From: [REDACTED]
Sent: 07 May 2024 18:17
To: Planning
Cc: [REDACTED]
Subject: 3/2024/0190 Lower Alston Farm Riverside Ribchester PR3 3XS
Attachments: 3 2024 0190 Overlay.pdf

Reference 3/2024/0190
Location Lower Alston Farm Riverside Ribchester PR3 3XS
Proposal Proposed engineering works to form an open silage clamp (three walls and slab only)

Lancashire County Council Public Rights of Way objects to the application and offers the following comments.

BLOCK PLAN SCALE 1:500

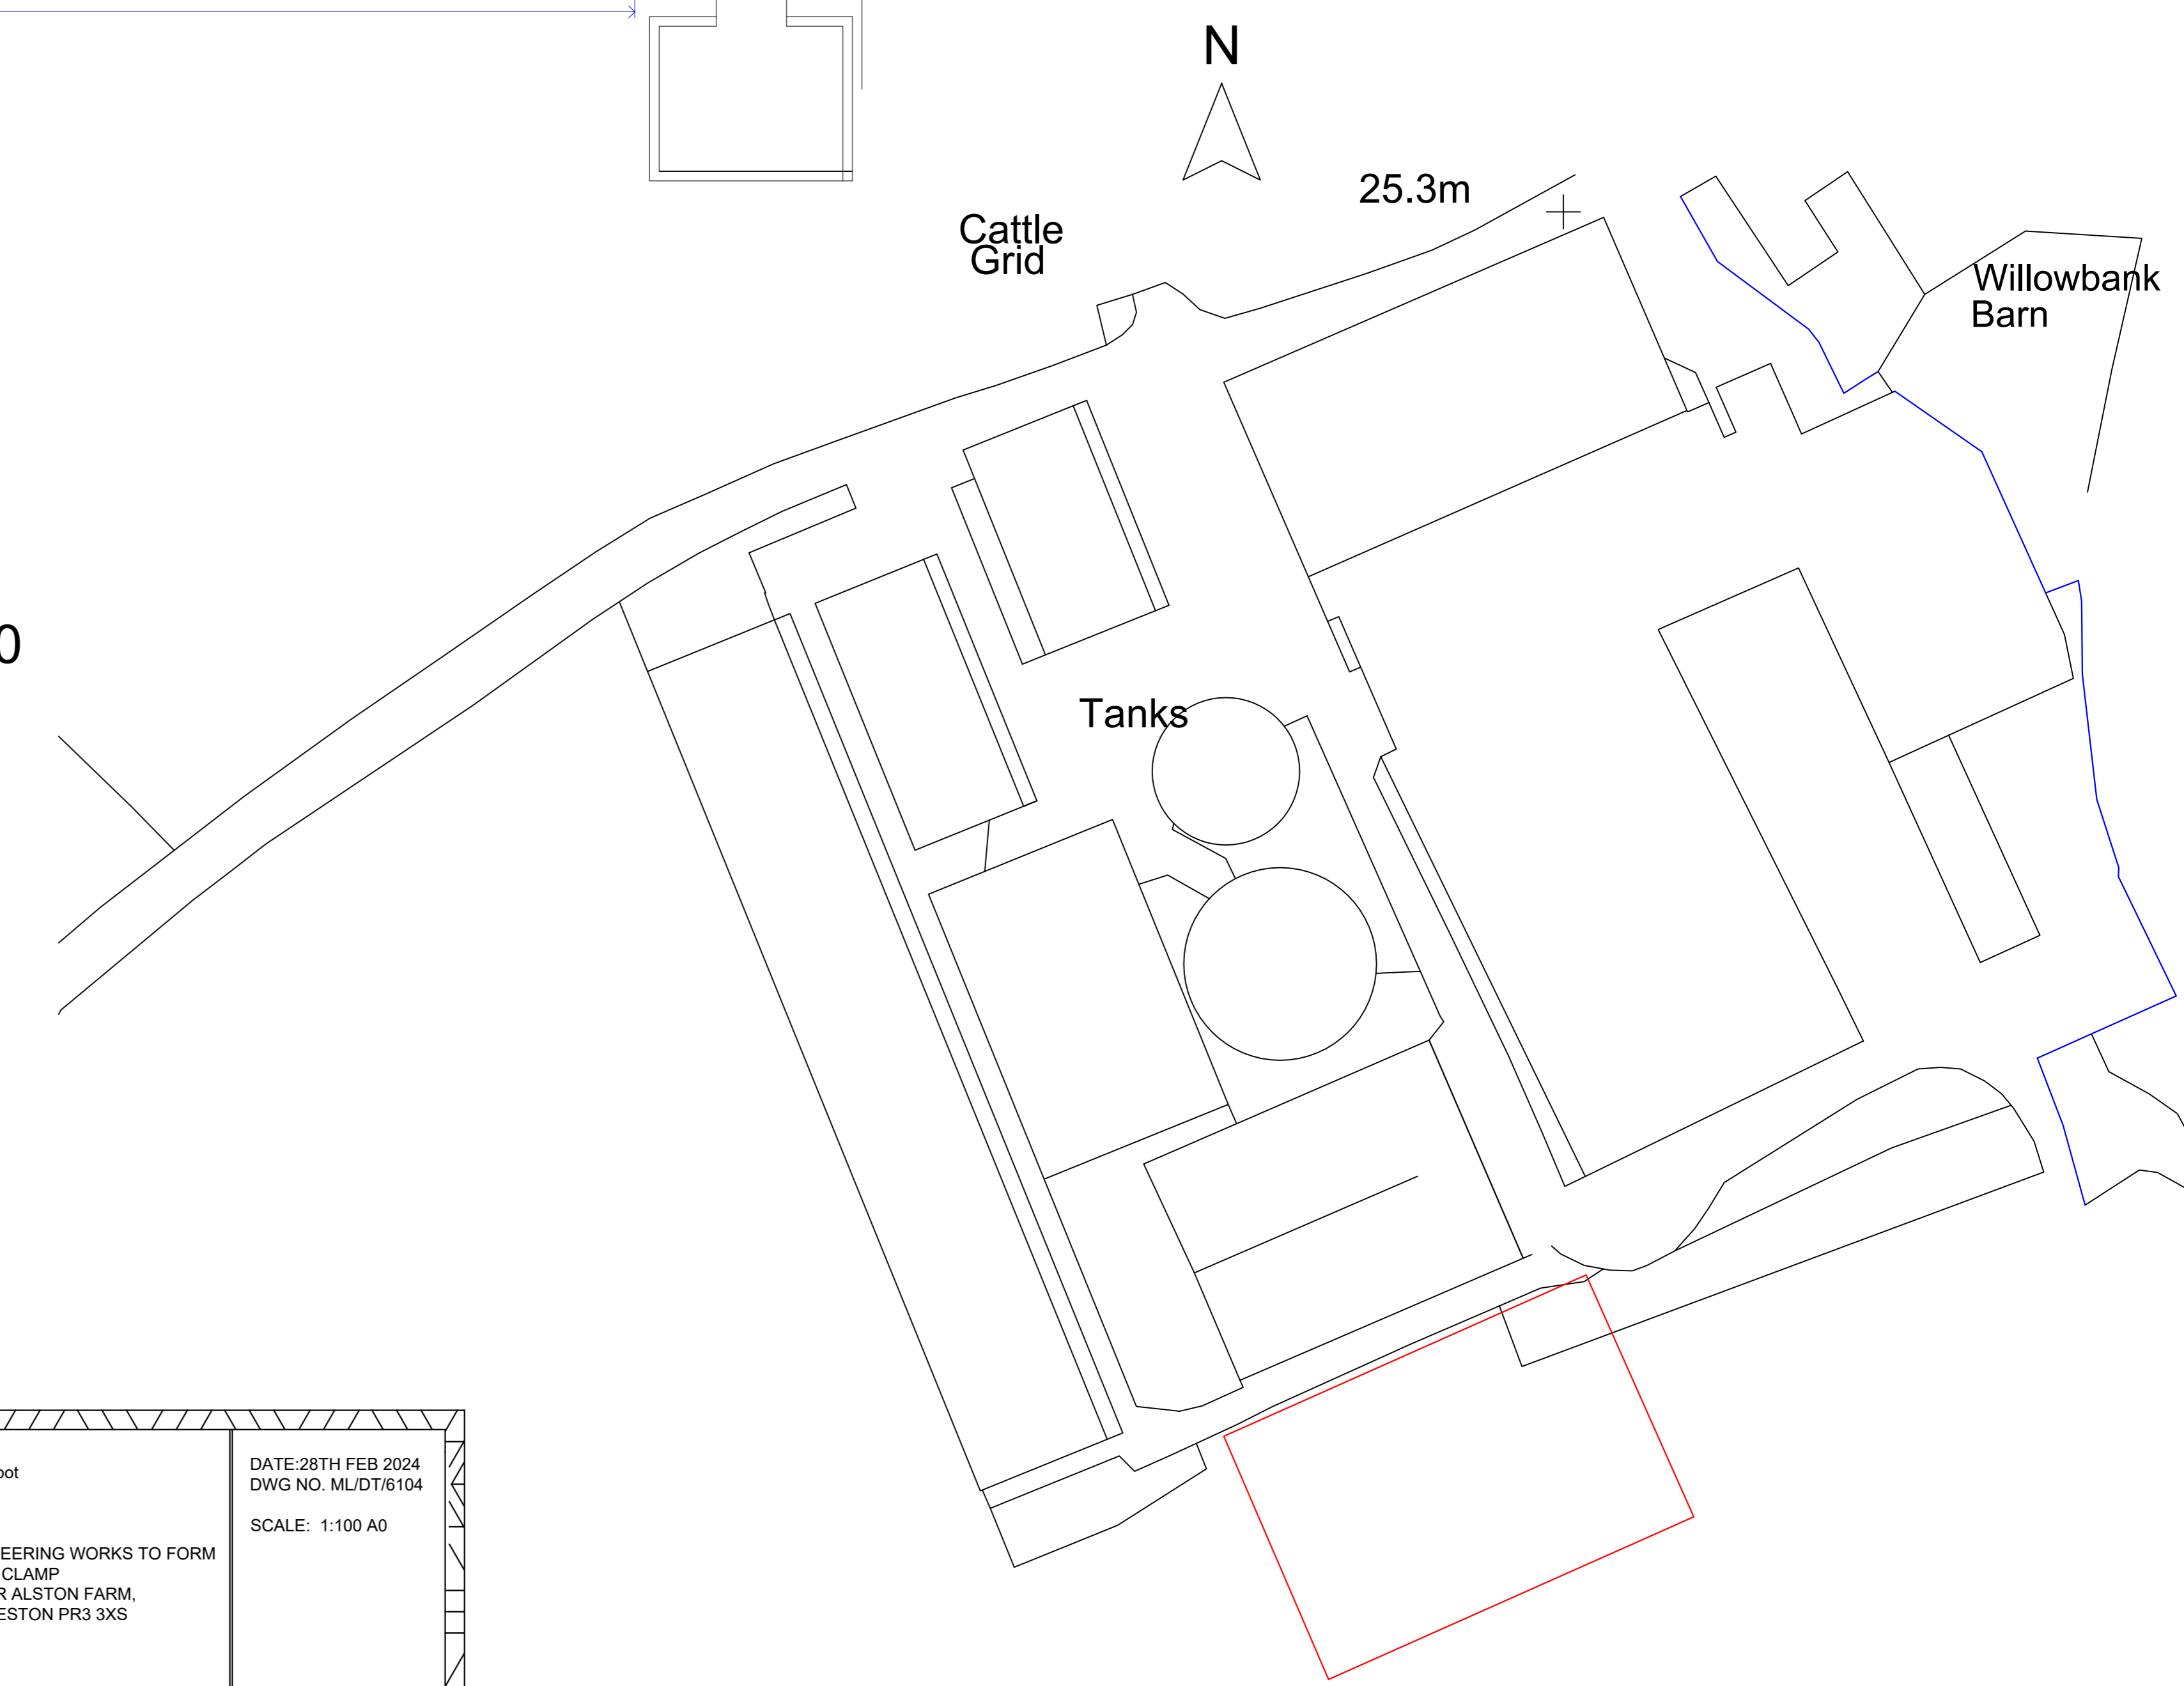
The proposed silage clamp will obstruct bridleway BW0335064, as shown on the attached overlay, requiring a Public Path Order under the provisions of the Town and Country Planning Act 1990 Section 257 (TCPA90 S257). TCPA90 S257 orders are administered by the authority that is considering, or has granted the planning permission, in this instance Ribble Valley Borough Council.

The detail of the exact alignment of the new route, the construction specification and any association works would need to be agreed with the Public Rights of Way Team before the necessary TCPA90 S257 Order is made. I can advise that the new route must have a minimum width of 3 metres, have a firm properly constructed surface with no gates or stiles crossing the new route.
